1.1.1 Velocity Transport Planning (VTP) has been appointed by Firethorn Trust (the Applicant) to provide highways and transport planning advice for an outline planning application relating to the development of up to 530 dwellings on land which forms part of the North West Bicester Eco Town development (Policy Bicester 1 of the adopted CDC Local Plan), located in Oxfordshire.

1.1.2 The Proposed Development description for the outline planning application, planning reference: 21/01630/OUT, is as follows:

TECHNICAL NOTE: RESPONSE TO OCC COMMENTS

CLIENT: Firethorn  
 PROJECT: North West Bicester  
 DRAWING: Illustrative masterplan  
 PROJECT NUMBER: I192  
 DRAWING NUMBER: SK004 CHECKED BY: MI/LA  
 REVISION: C STATUS: Draft  
 DATE: 14/04/2021 SCALE: 1:2,000

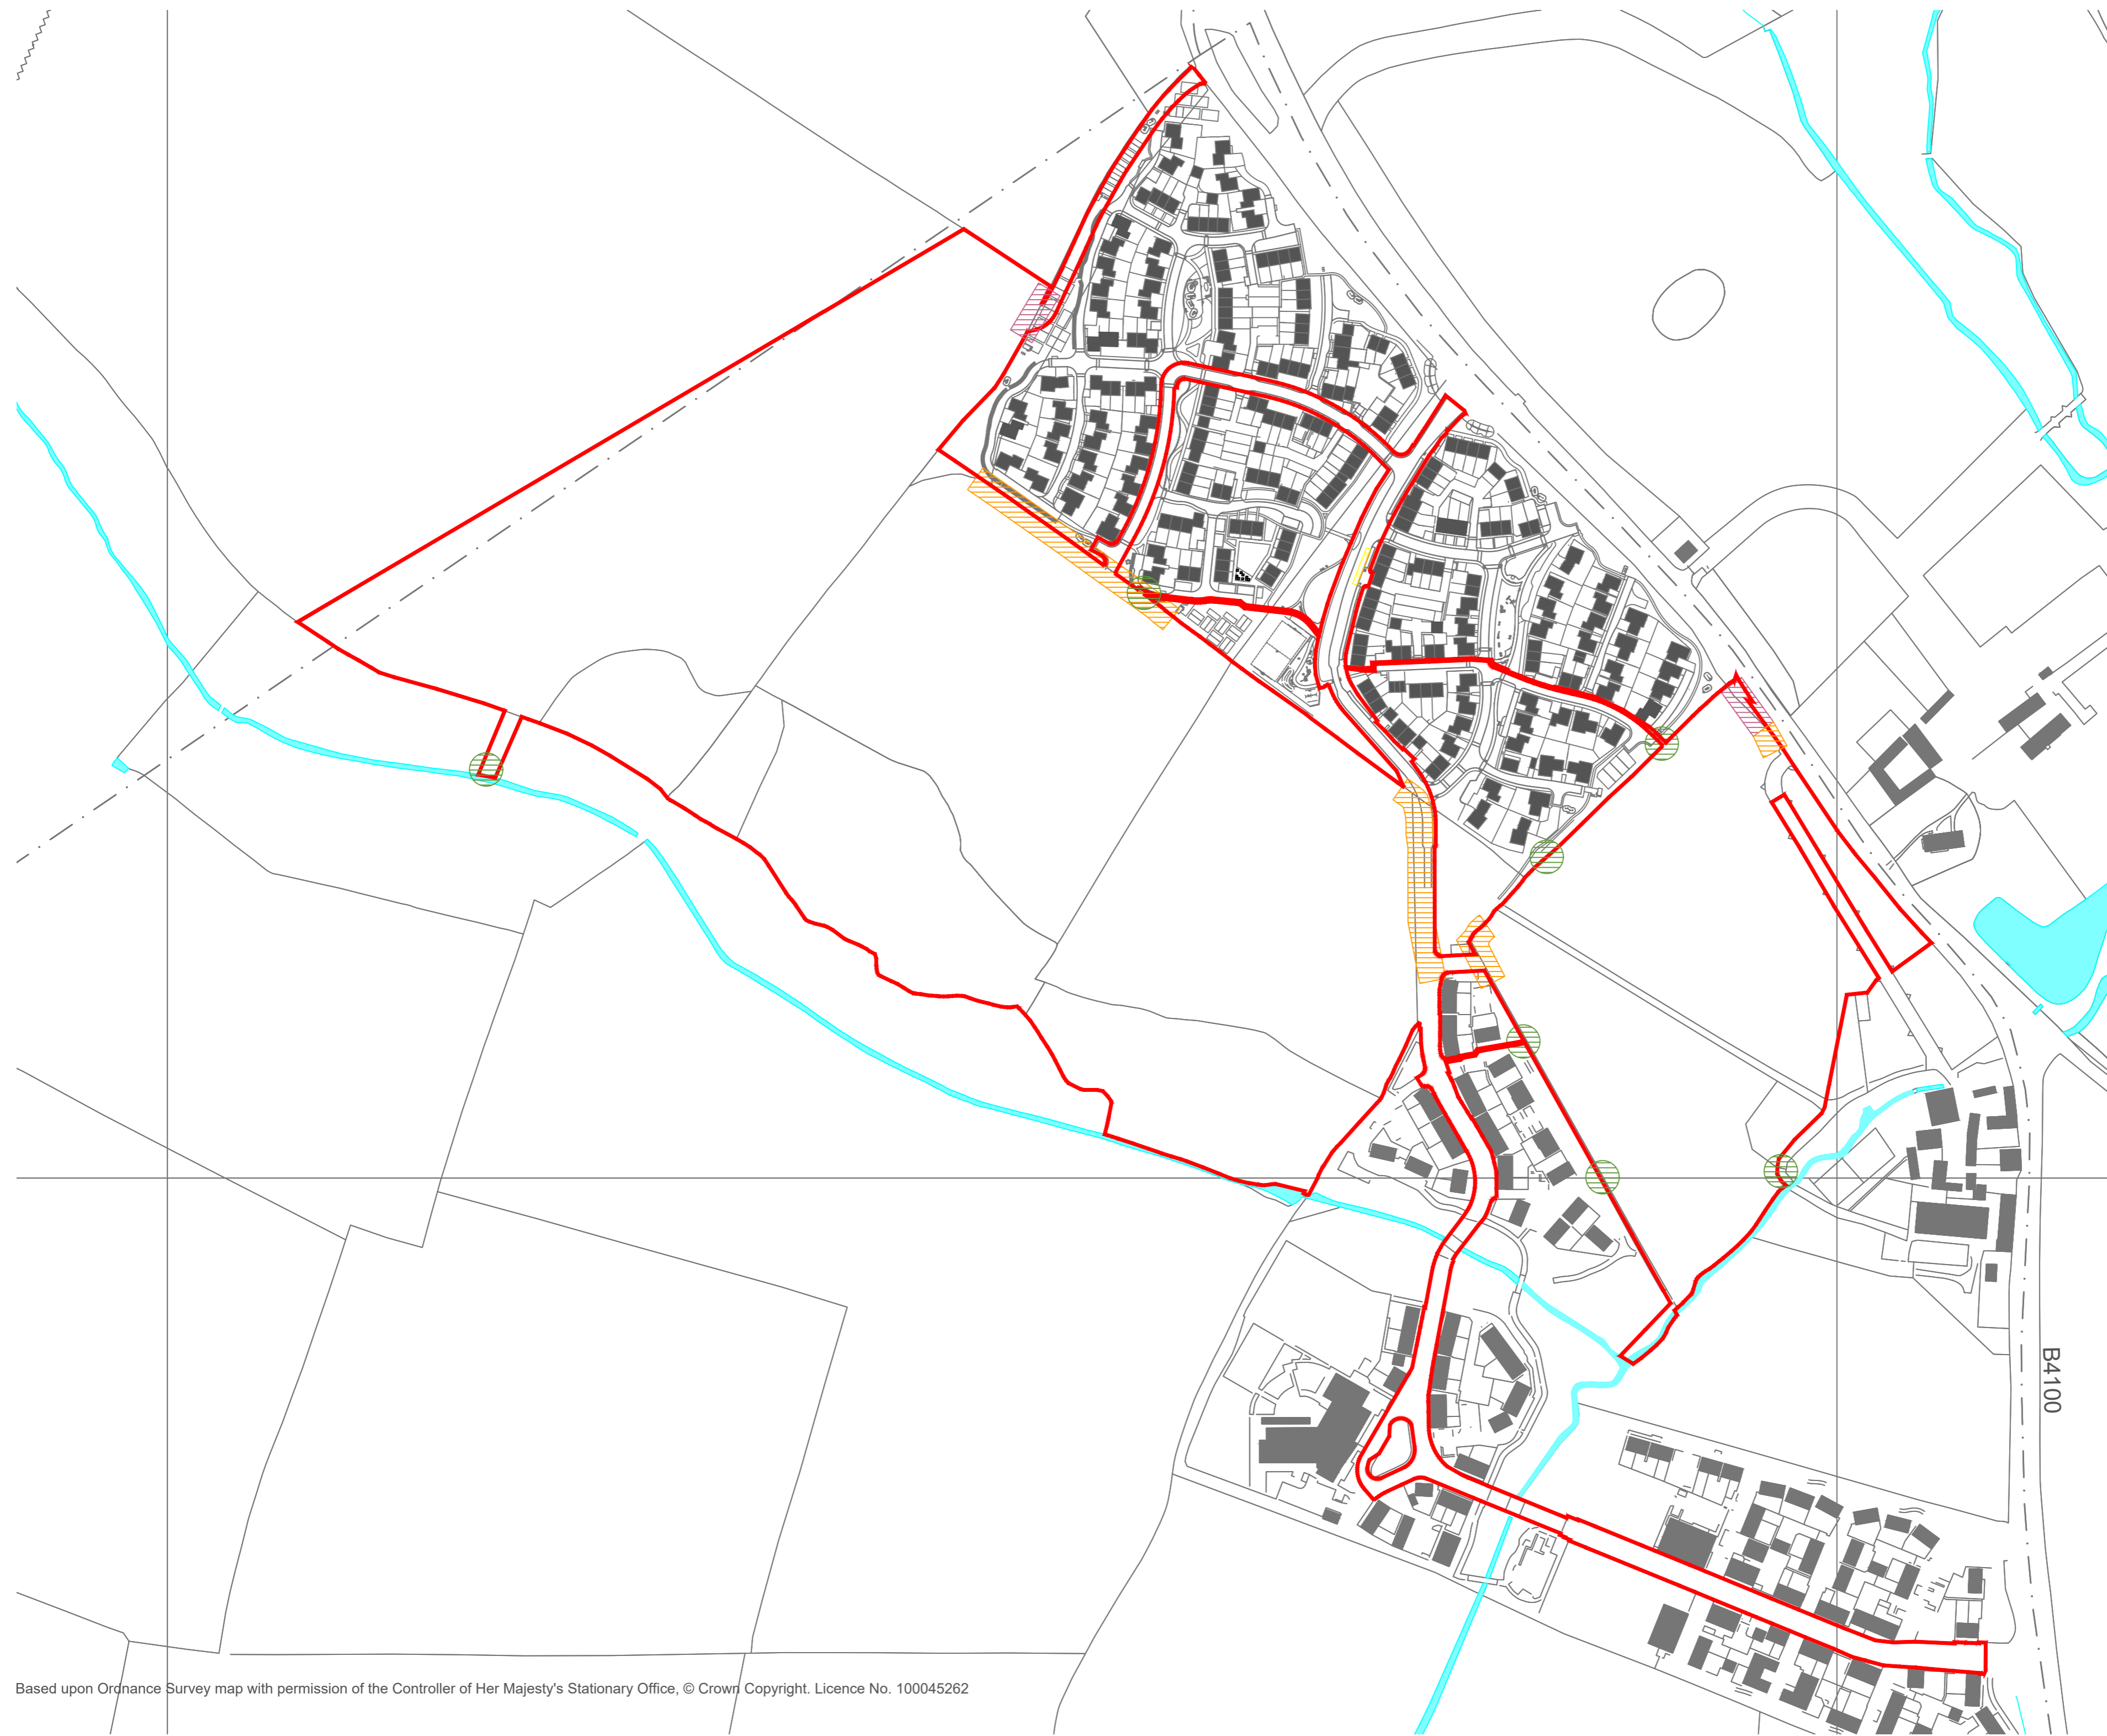
- 2.5.1 The Illustrative Masterplan (Rev C) that was submitted with the planning application (copy enclosed at **ATTACHMENT C**) identified a number of pedestrian and cycle links from the application site to the adjacent sites and the public highway. Some of these links were referenced as being “*potential pedestrian connections*”, and some were identified on the Illustrative Masterplan but not referenced as being a pedestrian or cycle connection at all.

- 2.5.2 Whilst the Illustrative Masterplan is only a representation of what might be delivered on the Application Site, it has informed the Access & Movement Parameter Plan, which has been updated in order to reflect the pedestrian/cycle connections that are being committed to. The Access & Movement Parameter Plan (Rev M) is included within **ATTACHMENT C**.
